TRANSPORTATION MEMORANDUM

**Sunflower Landscapes
El Paso County, Colorado**

PCD File No: VA265

June 2026

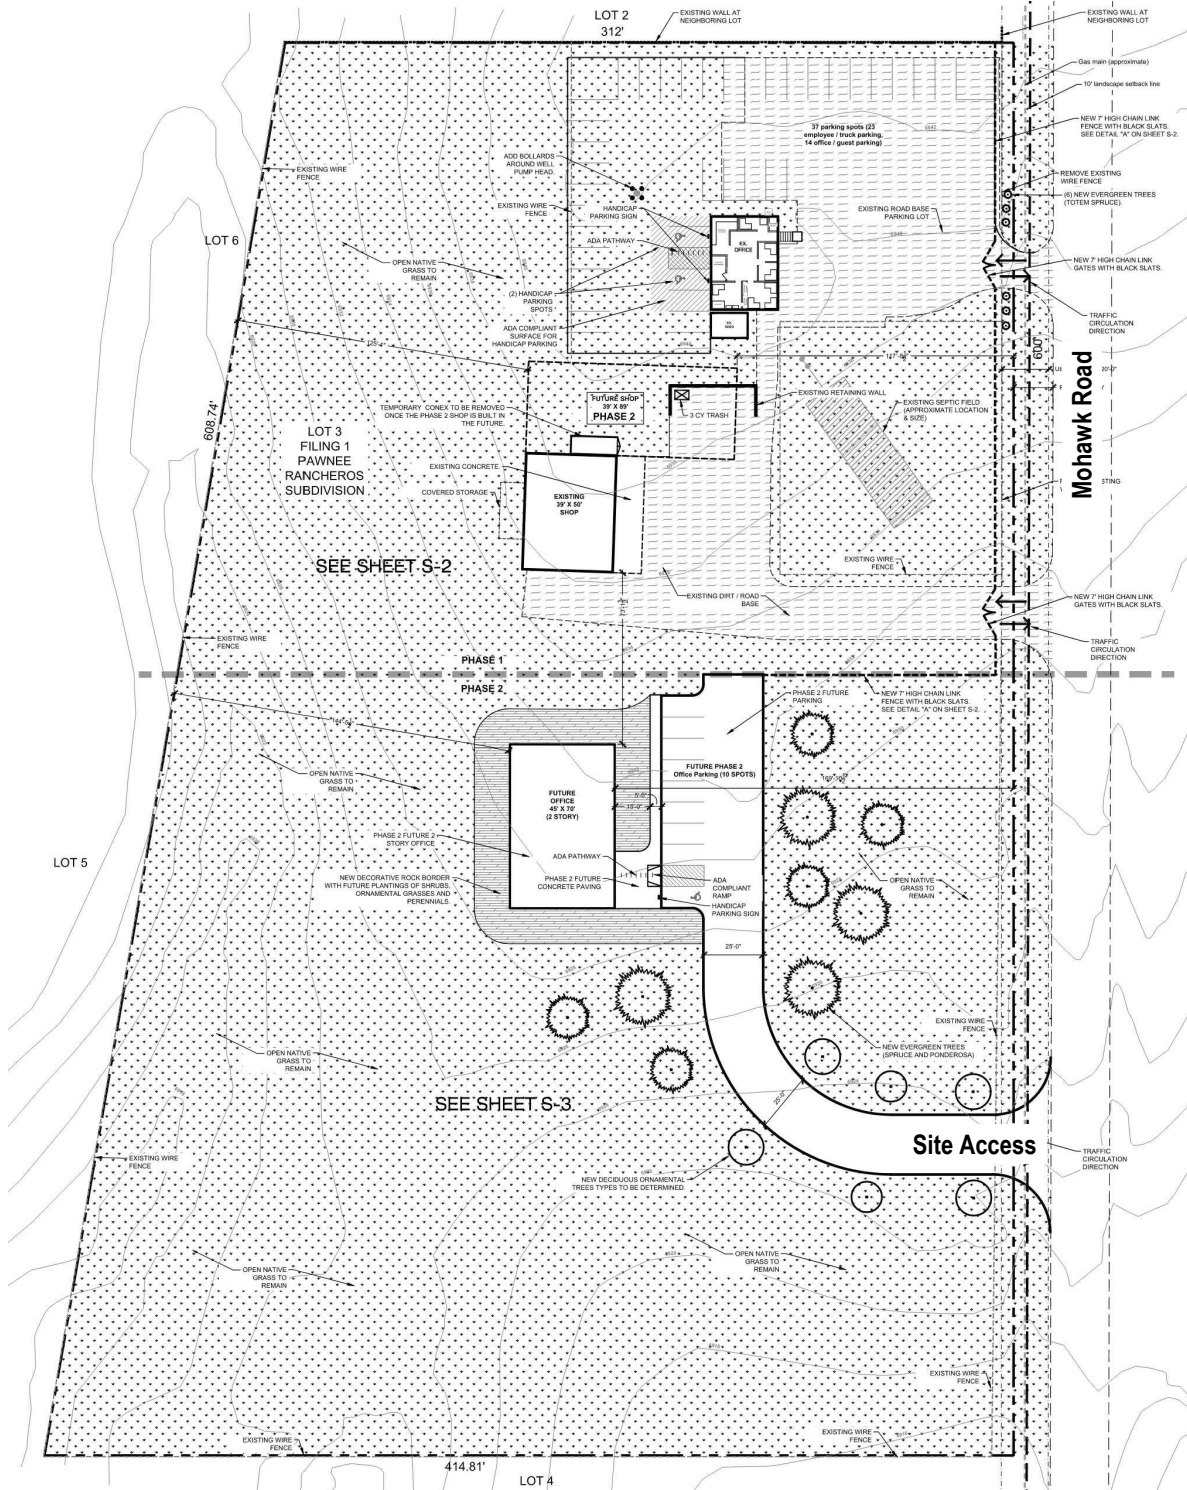
The description of the proposed access points does not match what is shown on the current site plan. The site plan depicts the existing access and a proposed access near the north side of the property; however, no access is shown across from the school driveway as described in the narrative. Please revise the site description and access-point analysis so they accurately reflect the access locations shown on the current site plan drawing.

This is a previous version of the site plan drawing. The current drawing does not depict a third access across from the school driveway. Please update and revise the access narrative on Page 1 and the corresponding access analysis so they accurately reflect the access points shown on the current site plan drawing.

Figure 4
BACKGROUND TRAFFIC - YEAR 2028
Volumes & Intersection Geometry
AM / PM Peak Traffic Hour
(ADT) : Average Daily Traffic

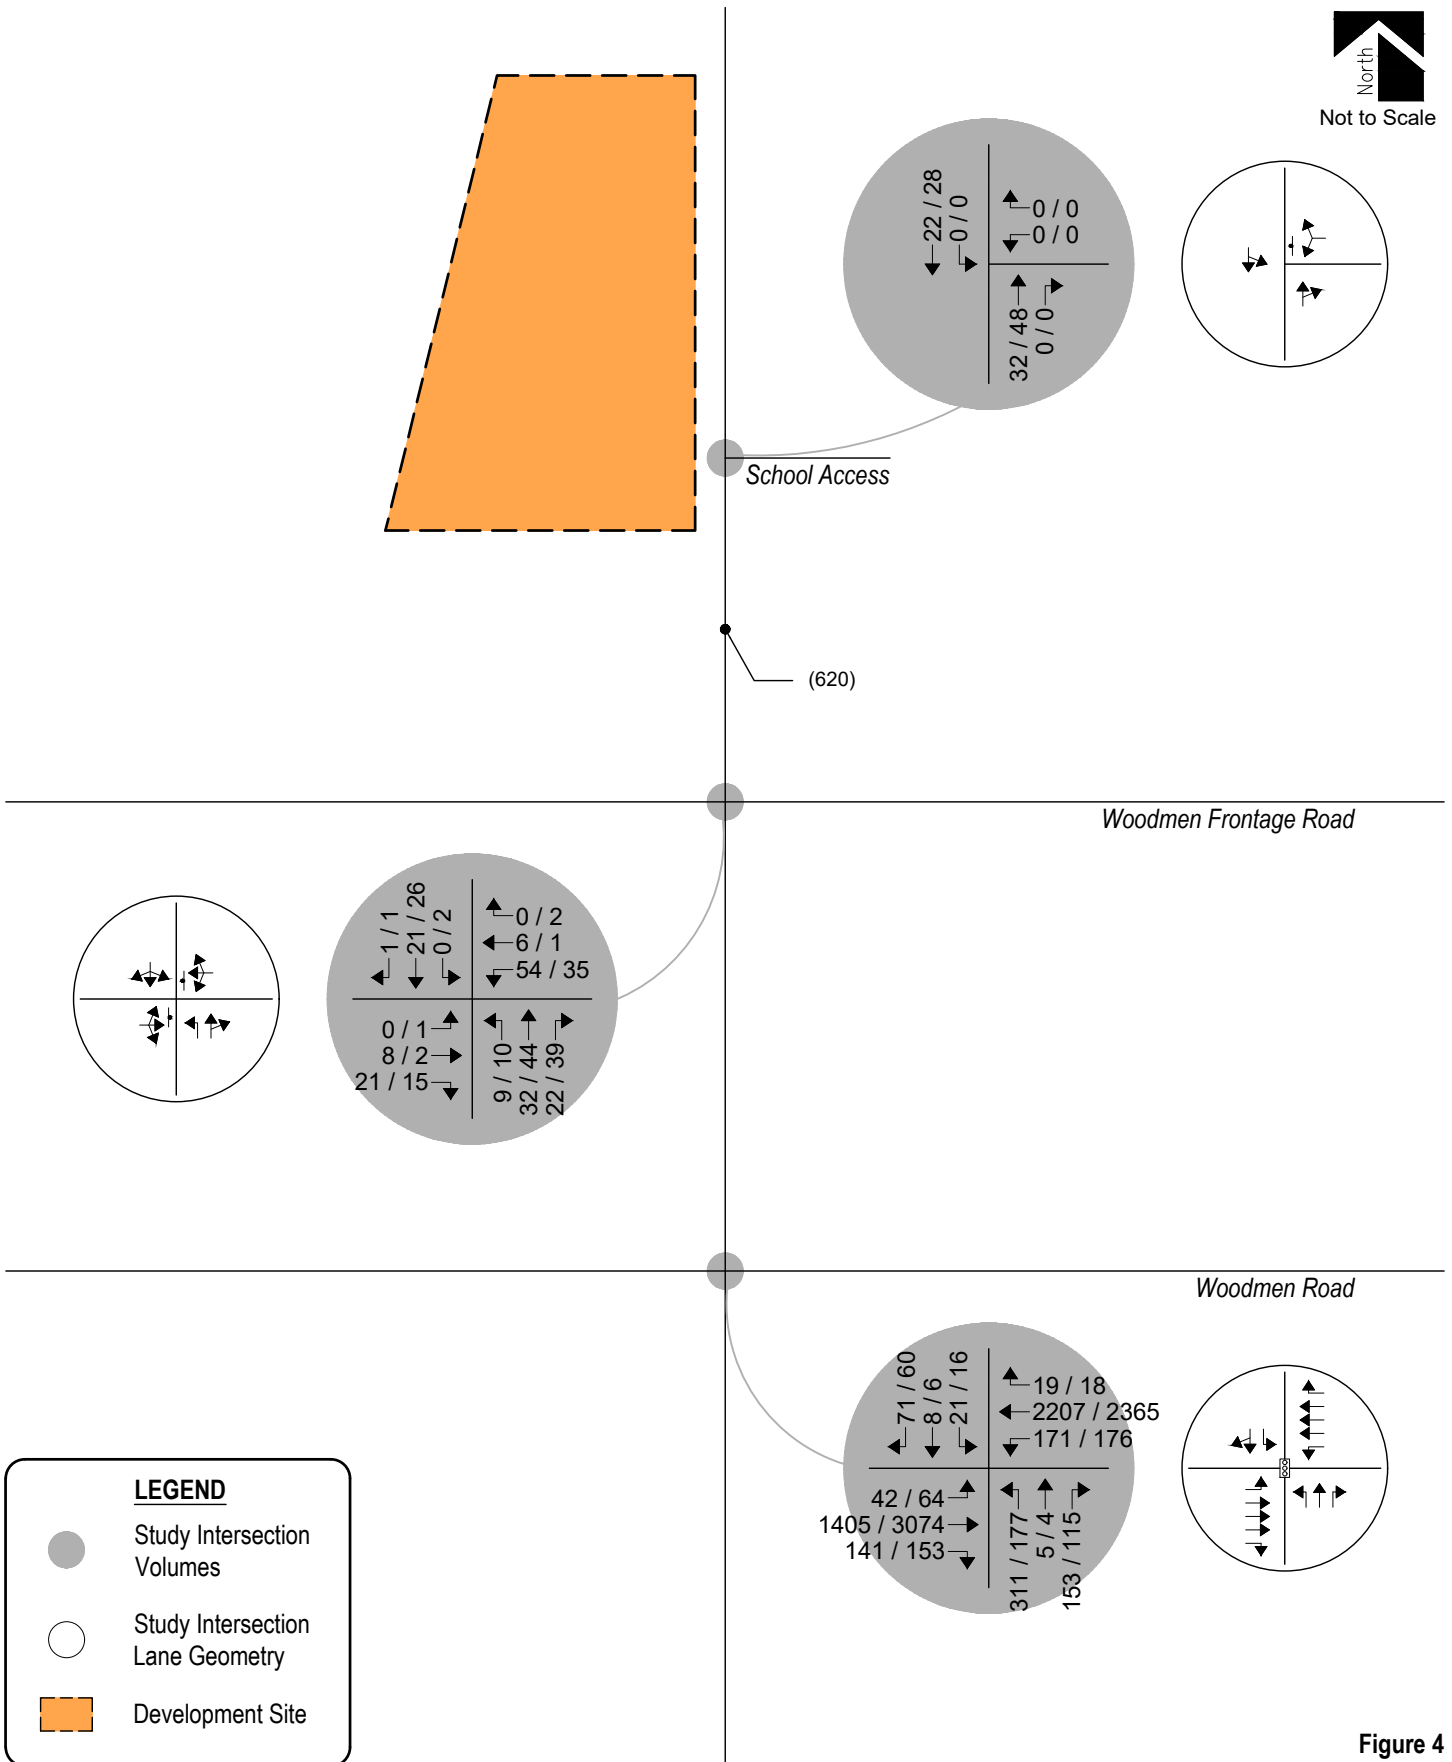
The soccer complex south of Woodmen Road is not mentioned in the narrative. Please include in the analysis and narrative.

Figure 6
TOTAL TRAFFIC - YEAR 2028
Volumes & Intersection Geometry
AM / PM Peak Traffic Hour
(ADT) : Average Daily Traffic

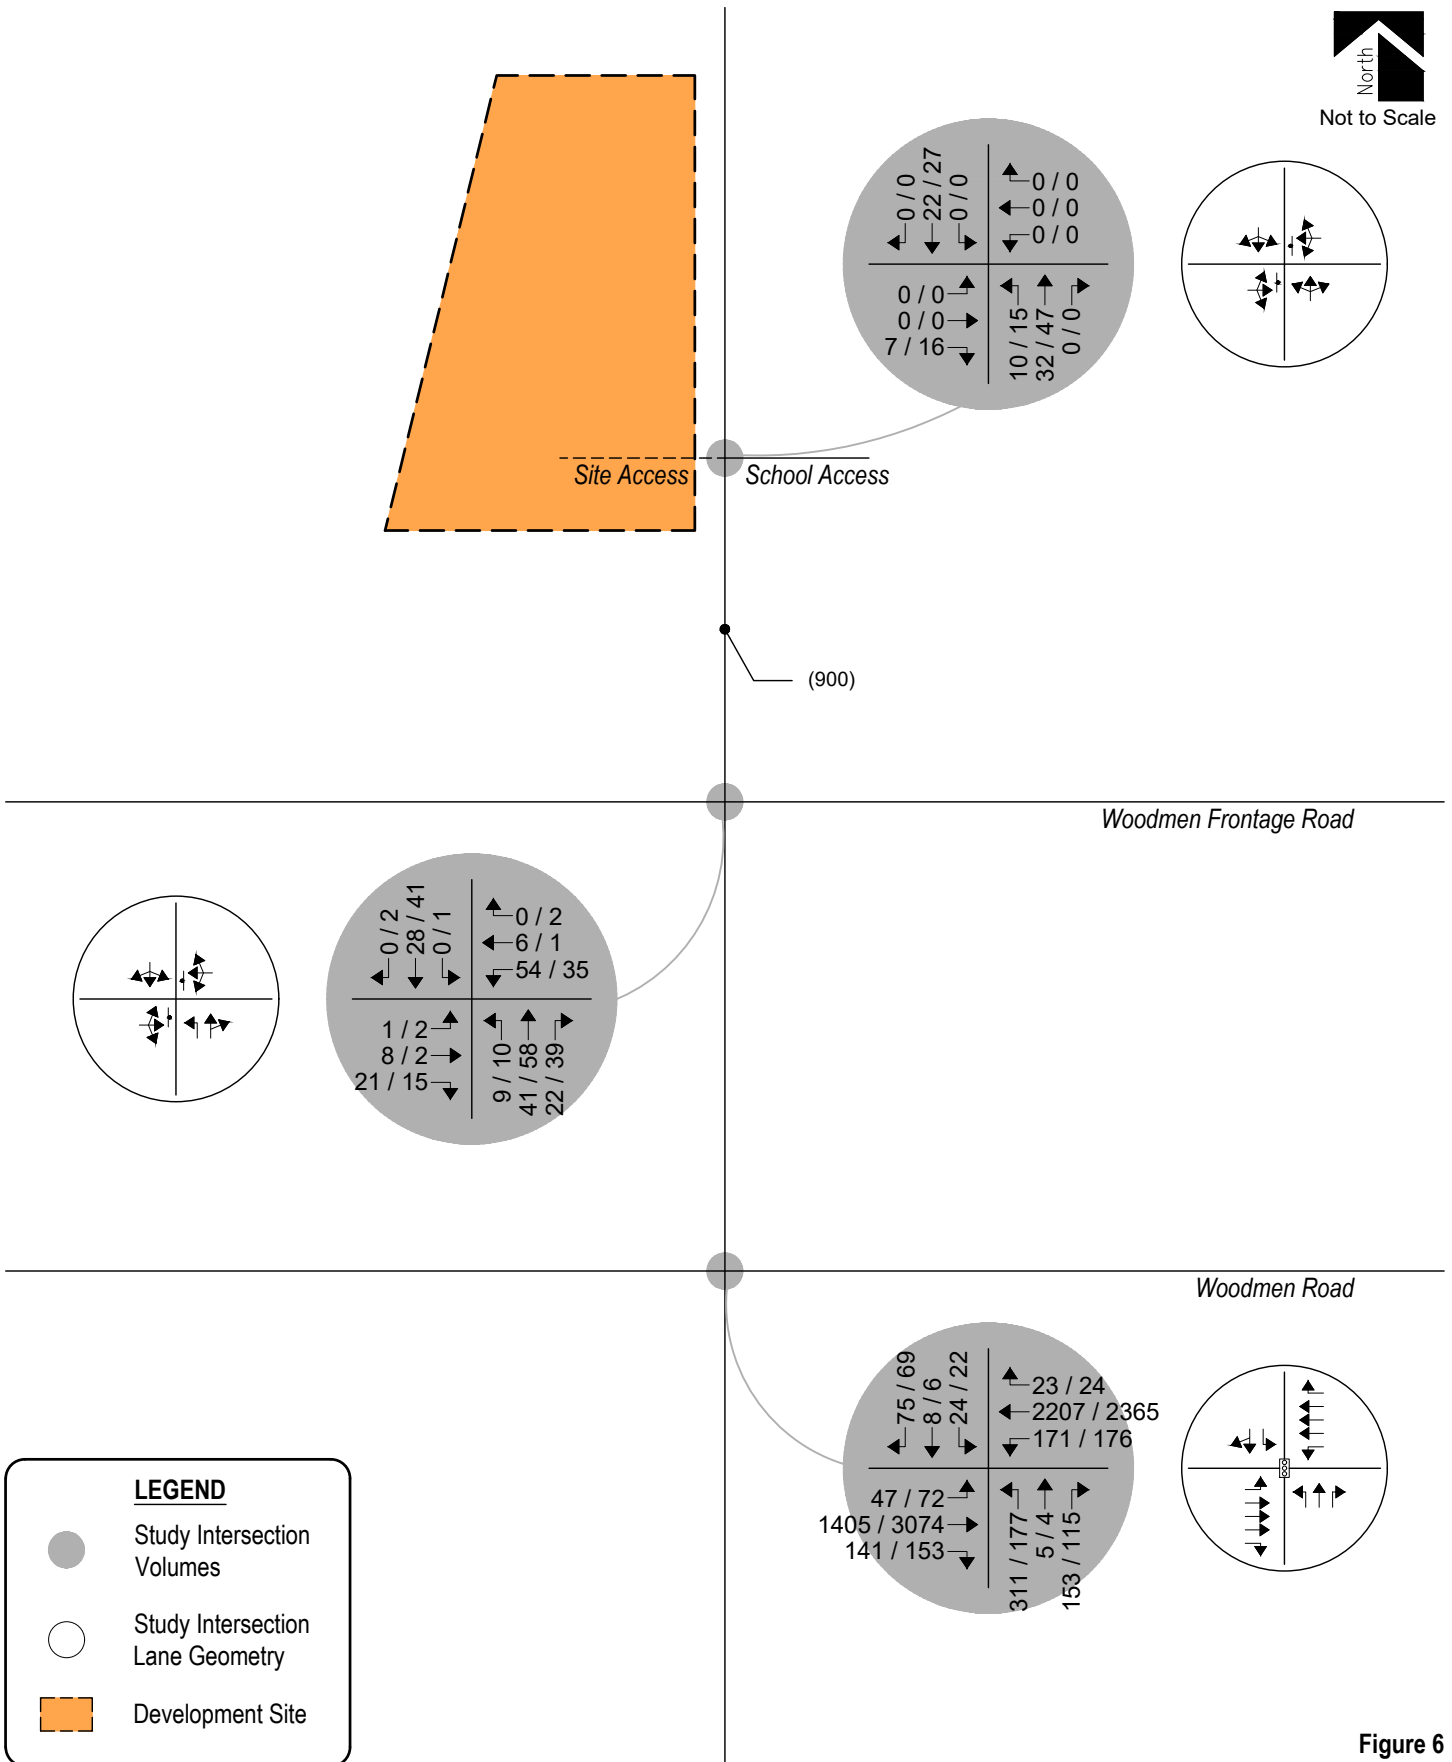
Please include turn lane analysis for the intersection of Mohawk Road and Woodmen Road and state whether the existing turn lanes are adequate.

Sight Distance Exhibit

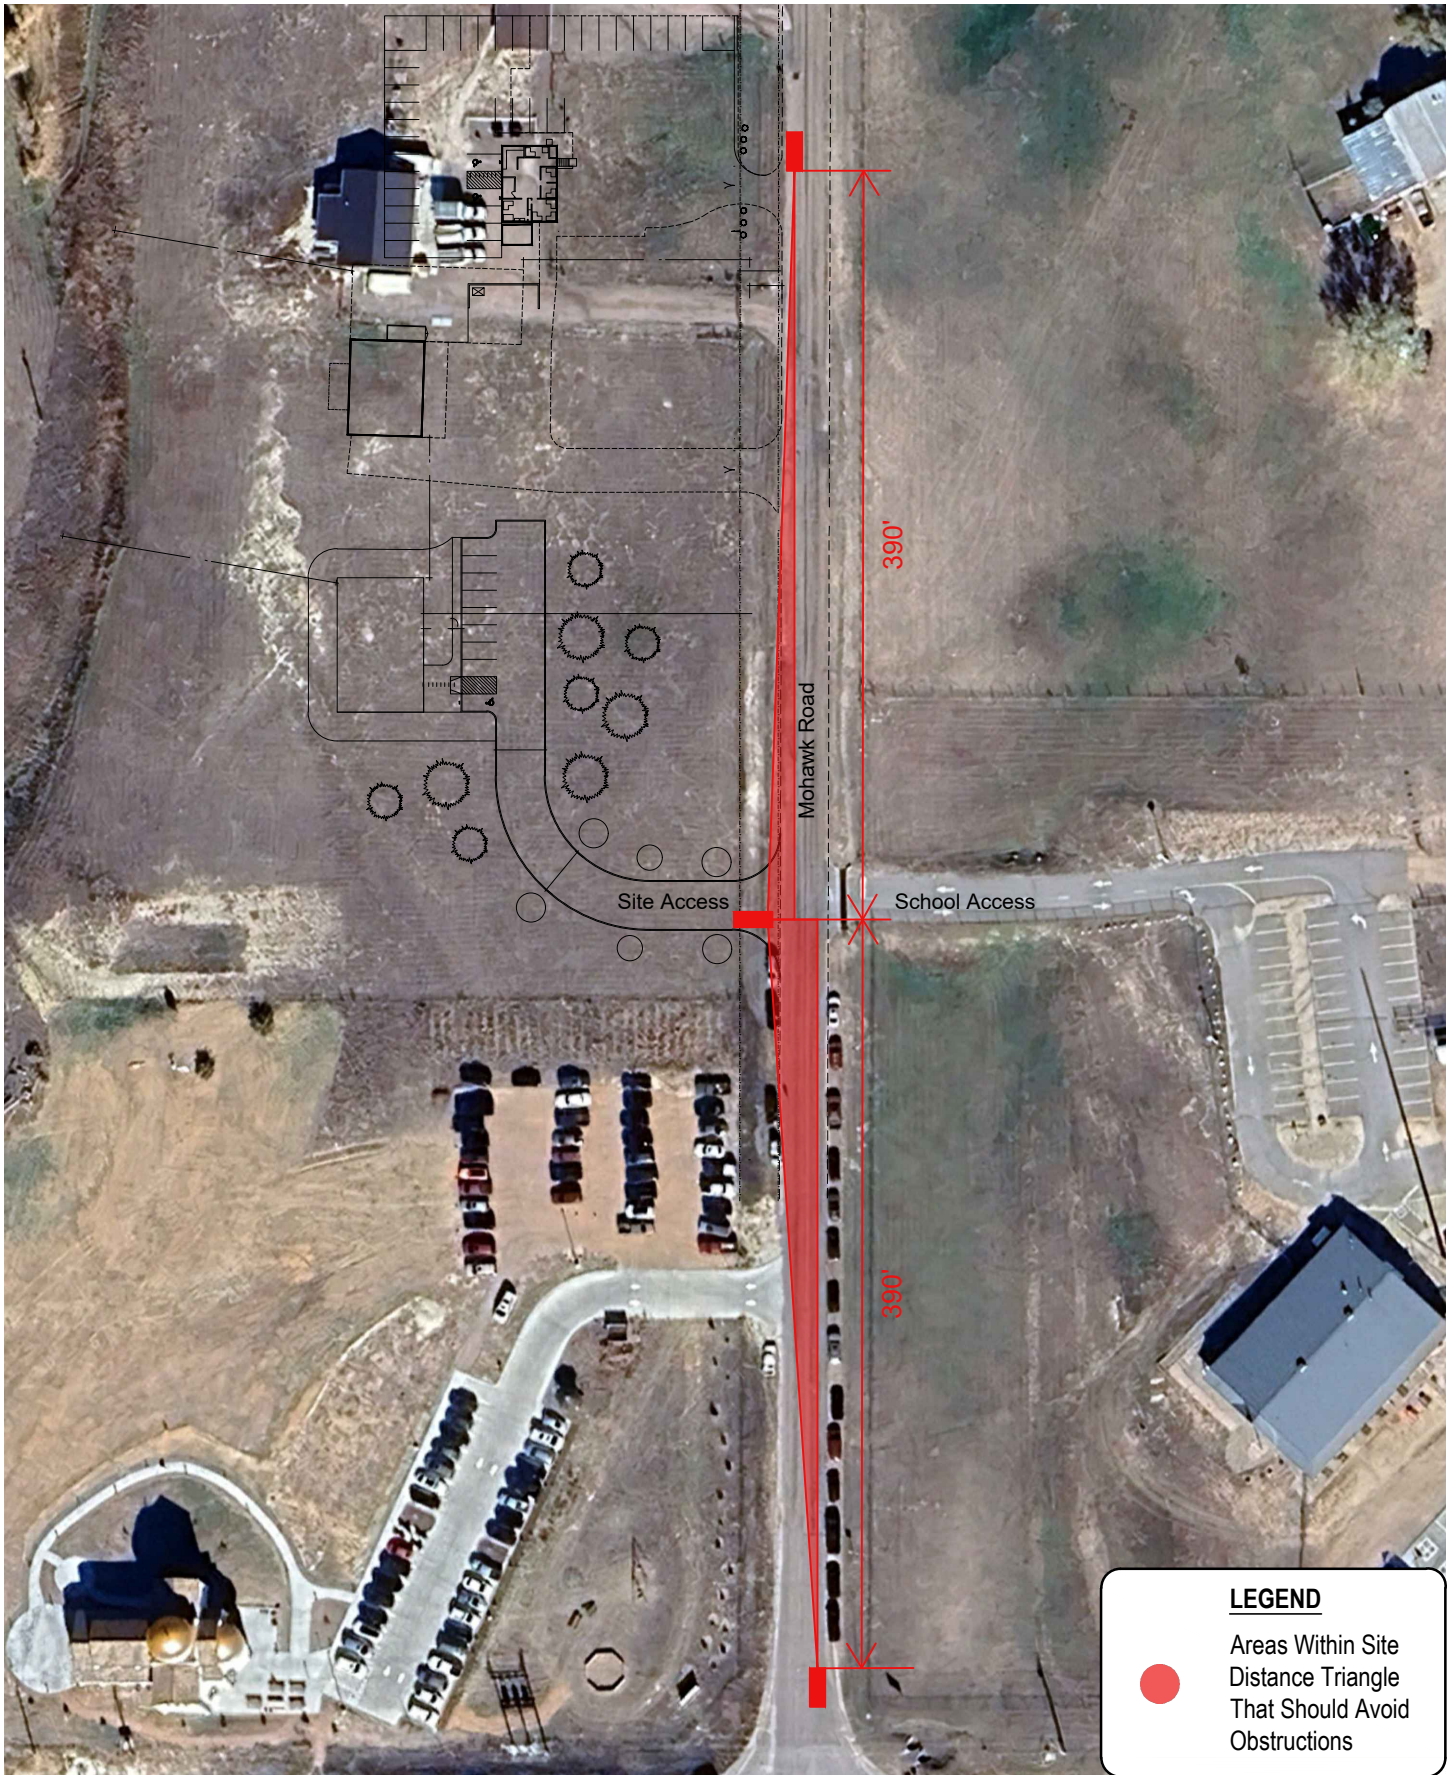
A two-dimensional exhibit does not accurately reflect whether the required sight distance is met, the vertical profile must be considered. A statement must be included whether or not the sight distance is met.

The sight distance analysis may be performed at the site development plan application instead of the variance application. If the applicant is planning to postpone the sight distance analysis, please clearly state that in this report.

Please note the the sight distance analysis shall be reflective of the type of traffic utilizing the site.
